Application No: P/21/21/HH
Site Address: 6 The Green Pagham PO21 4RZ
Description of works: Loft conversion to form new first floor with front and rear dormer projection

Thank you for your internet representation made on 8th March 2021 which has been recorded as an objection with the comments as follows:

Proposed

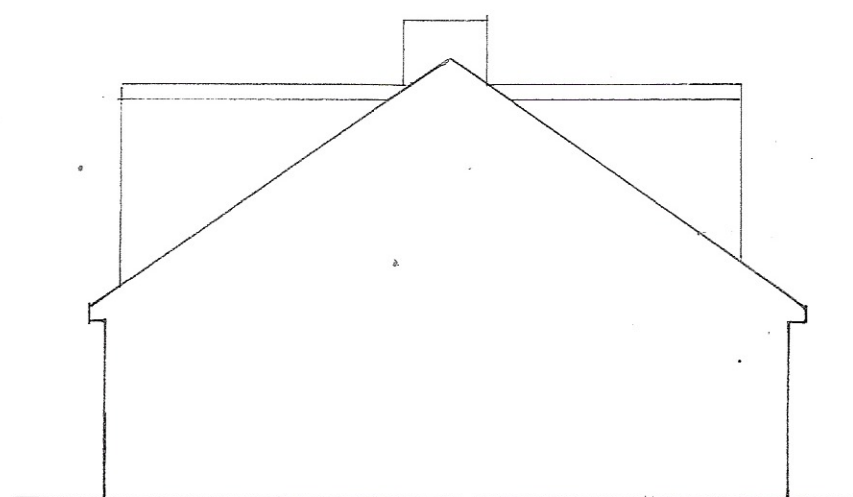
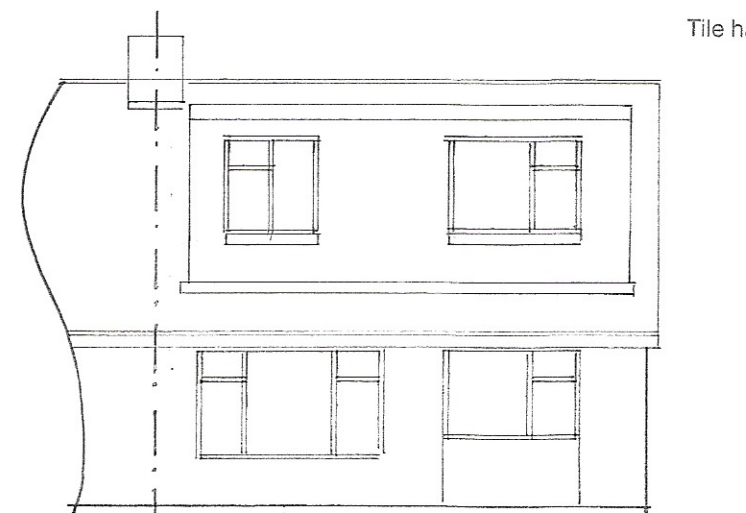
My only objection is the proposal of a FRONT projection as no other property in the road has anything similar and as such it would change the dynamics of the street
